Planning Services Sign Permit Review Form

Date of Submittal	Application Number	Applicant	Landowner
5/28/2025	SIGN2506-0003	Clayton Constructors / Post Nursery	Harrington Properties

Contact Person	George Gee	Contact Number	919-554-4002
Sign Location	NC 27 W	PIN Number	0528-10-7539.000

**SITE PLAN**  
 FOR

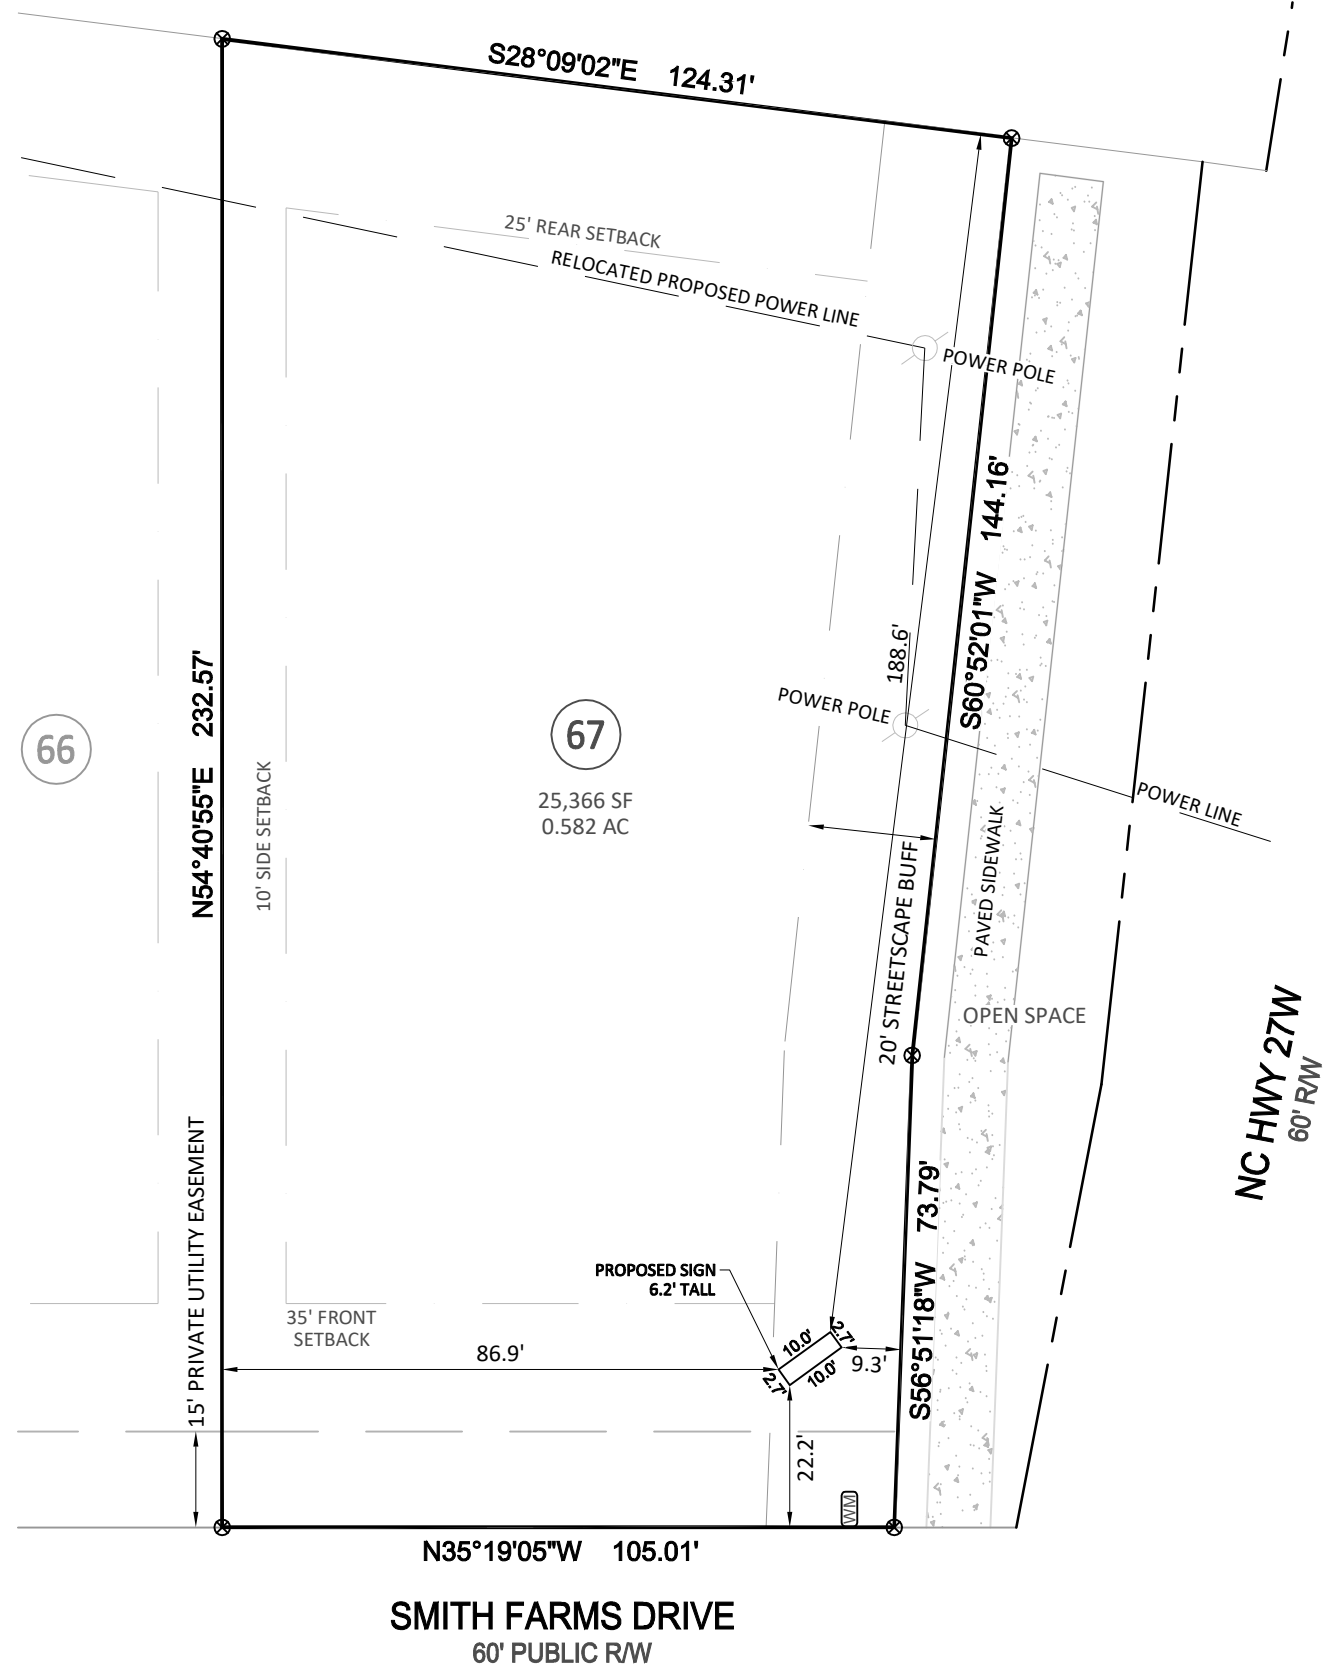
Comments	Specify sign location on site plan. Give reference to any property line, dedicated easement or right of way.
----------	--
